**PLANNING ACT 2008  
THE INFRASTRUCTURE PLANNING (EXAMINATION PROCEDURE) RULES 2010**

**Application by London Resort Company Holdings for an Order granting Development  
Consent for the London Resort (ref: BC080001)**

**RELEVANT REPRESENTATION  
by the Port of London Authority**

Scale: **1 : 2500 @ A1** Sheet: **2 of 9** Revision: **0**

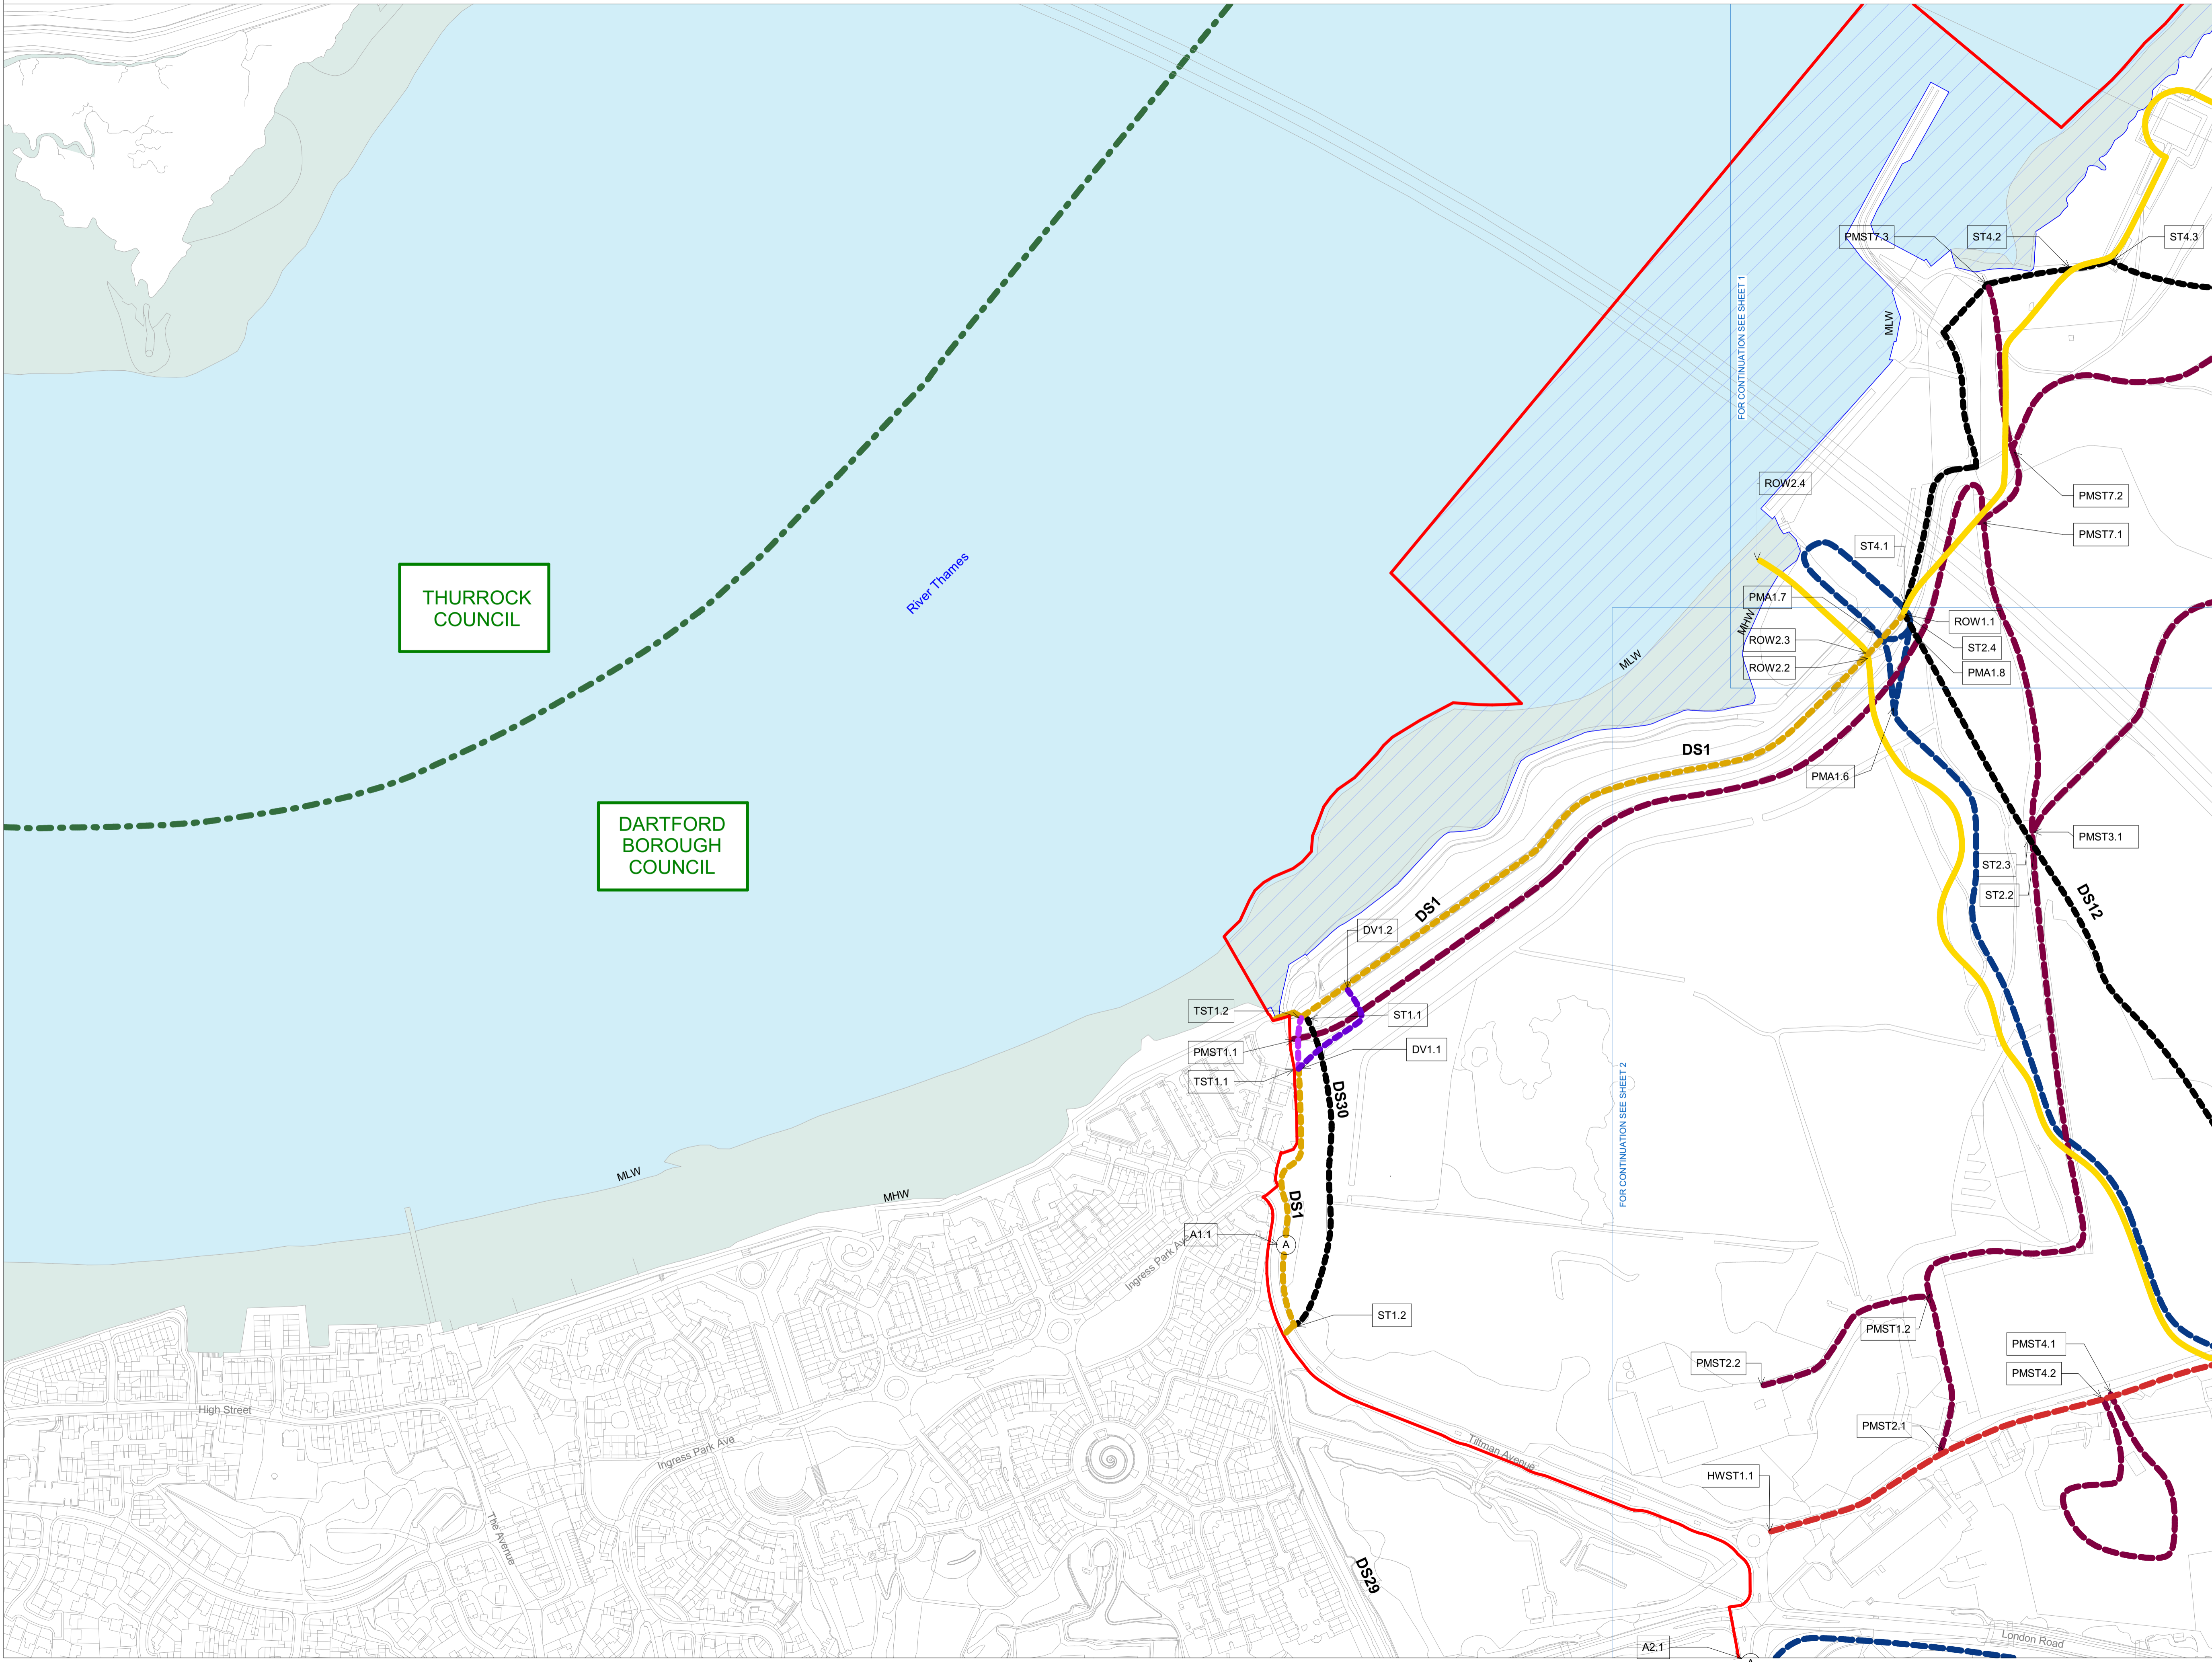
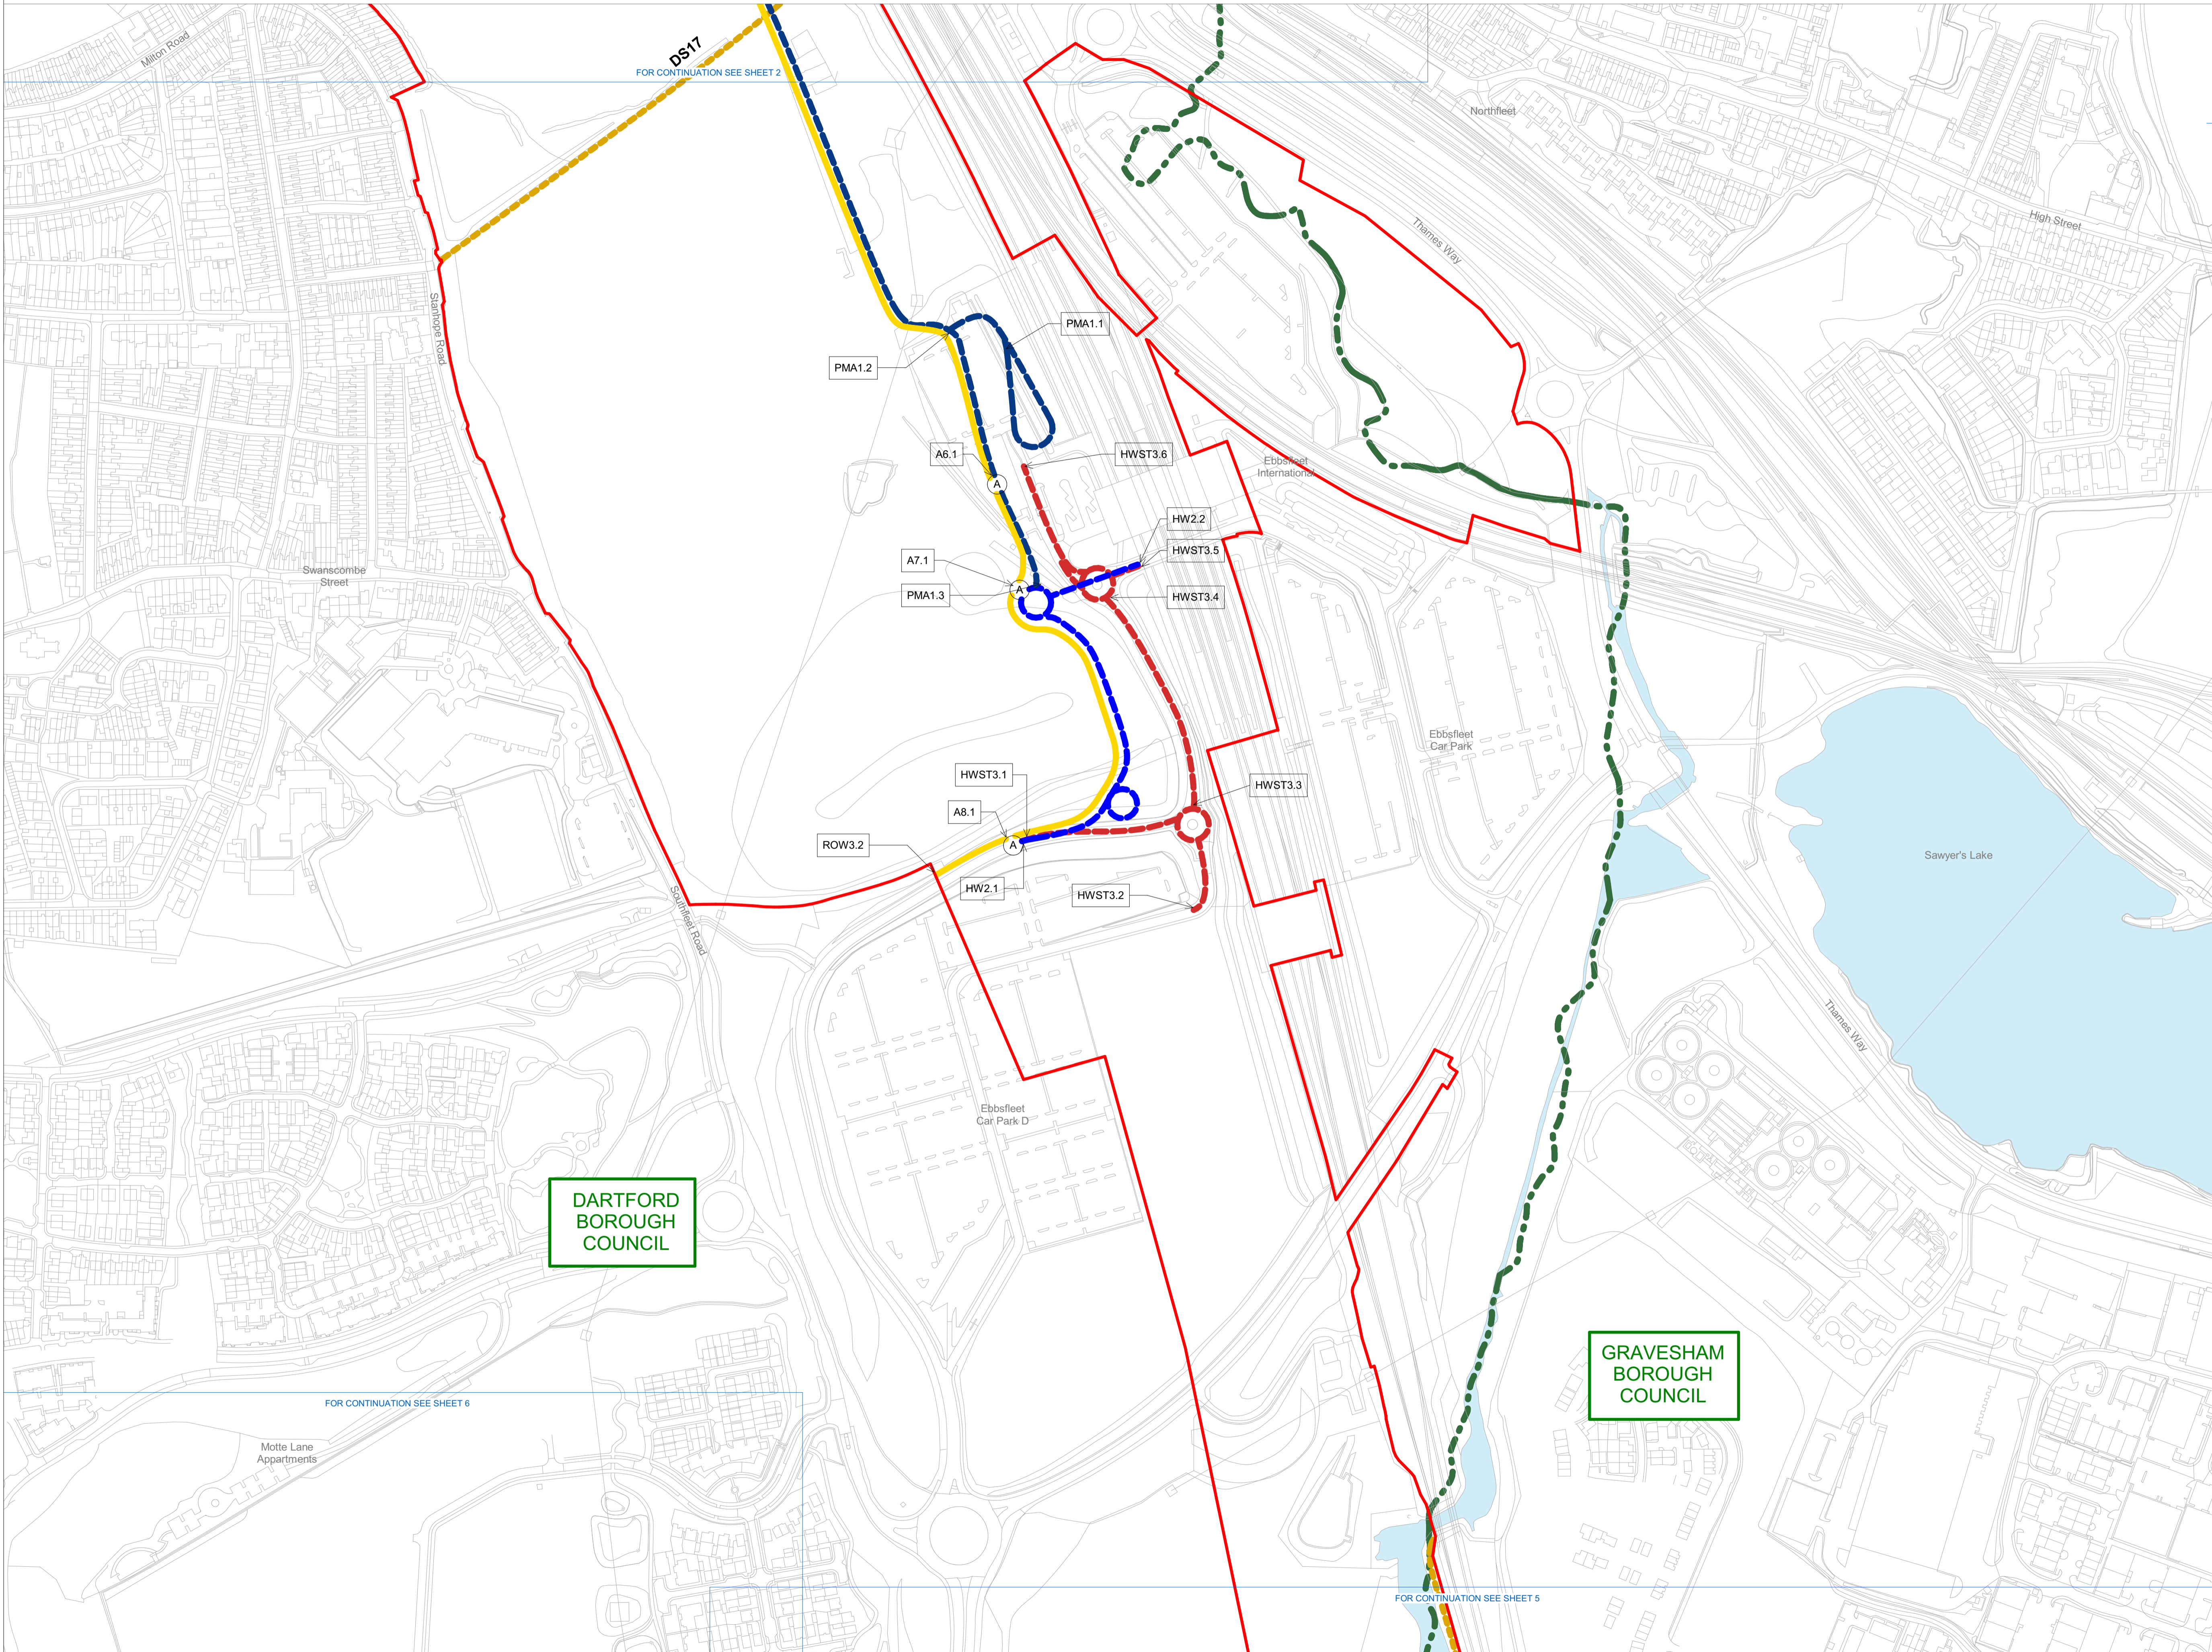
4. **Drafting of the Order and plans**
  - 4.1 The drafting of the Order and the plans submitted with the application fail to clearly indicate the applicant’s intentions regarding the river and its foreshore. There is insufficient detail provided in respect of works and operations within the river and foreshore to provide the PLA with certainty as to the nature and extent of those works and their construction, and also the scope and extent of any temporary works in, and possession of, the river.

of the disapplied provisions. The PLA takes issue with other provisions of the Order, including but not limited to: interference with/suspension of public rights of navigation (arts. 31(13) and 39); the amendment of existing byelaws (art. 49) and the making of new ones (art. 50); and the extinguishment of existing river works licences (art. 9(4)).
